Submission ID: S38636AB1

APP-186 06.03.16.04 Environmental Statement Volume 3 - Appendix 16.4 Glint and Glare Assessment - Table 23, Plate 13 Impact classification - Road receptors north area

Drawing file: published-documents / EN0110012-000335-02.12.01 Outline Environmental Masterplan_Site1_Sheet1.pdf

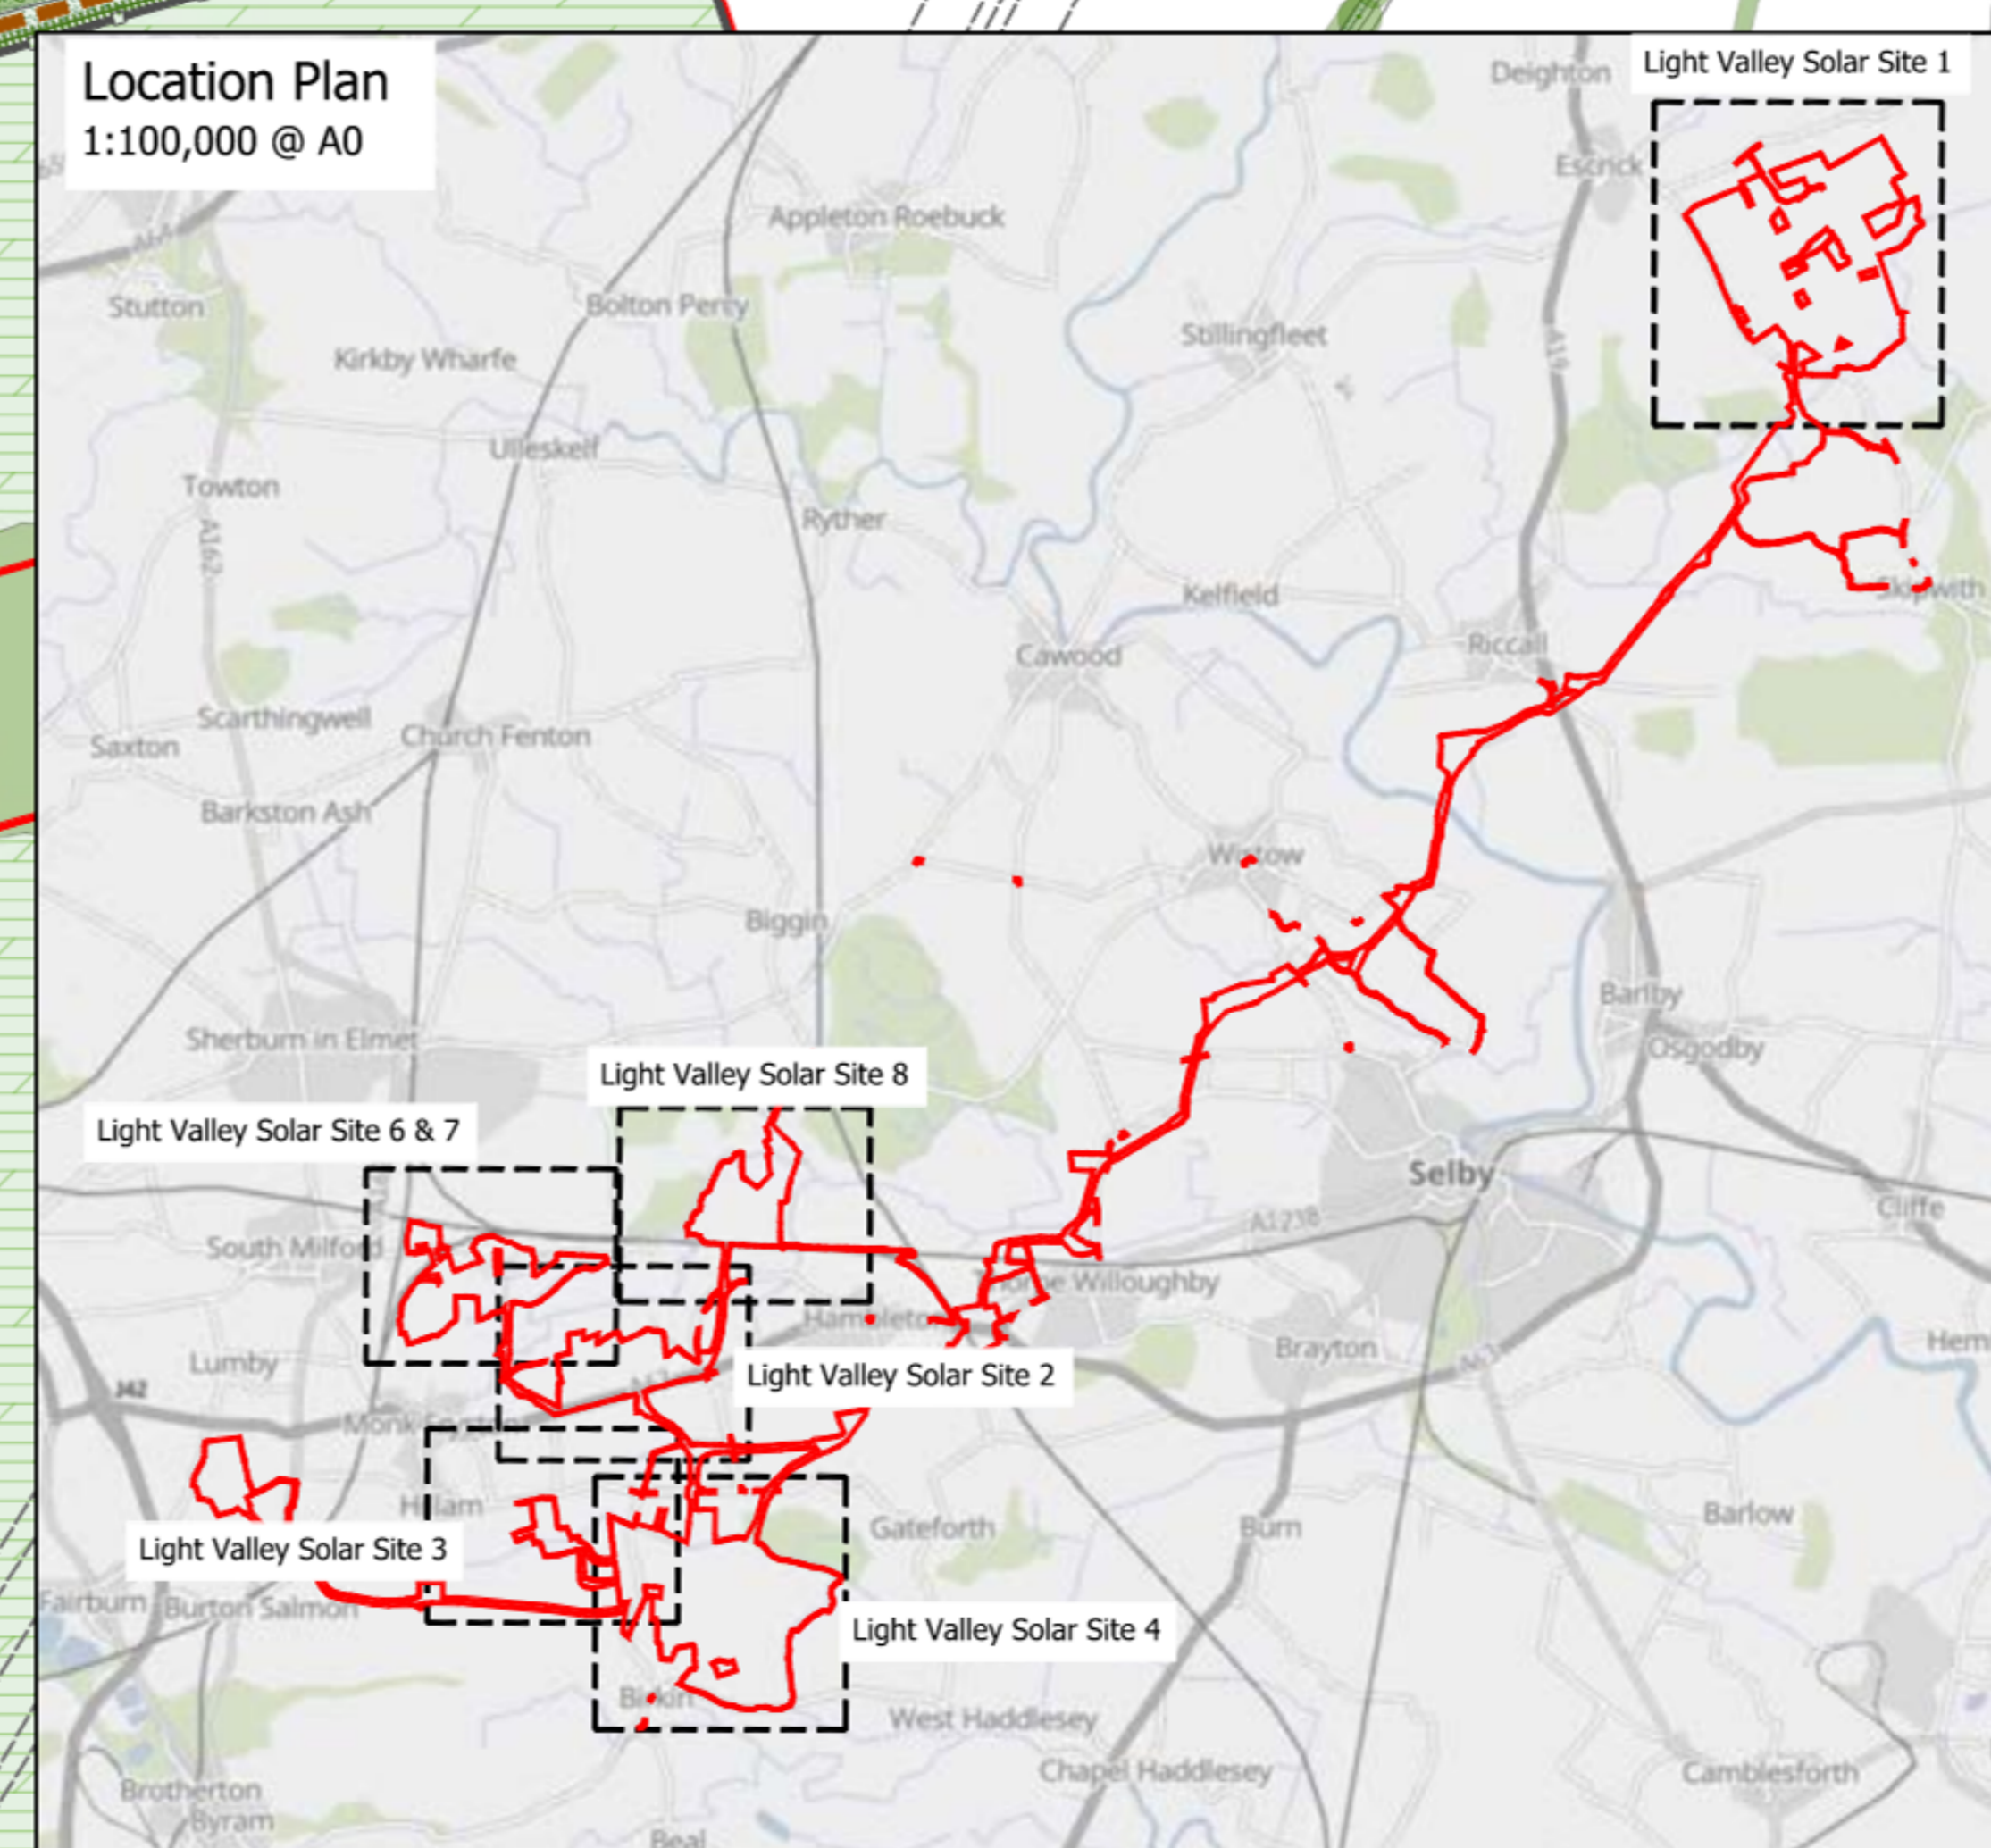
I would also add that views into Solar Development Site from Skipwith Road to the west of Solar Development Site 1 are no longer largely curtailed by road side hedgerows, apart from occasional gaps into the fields as stated in APP-048 06.01.10 Environmental Statement Volume 1 Chapter 10 - Landscape and Visual 10.7.96, due to the removal / cutting back of existing hedges and vegetation leaving large open gaps as shown in the photos attached.

In view of the above, I consider that the need for the provision of screening in the form of advanced planting at Solar Development Site 1 receptors N11-N21, 24 that would be predicted to significantly screen reflecting areas should be re-assessed.
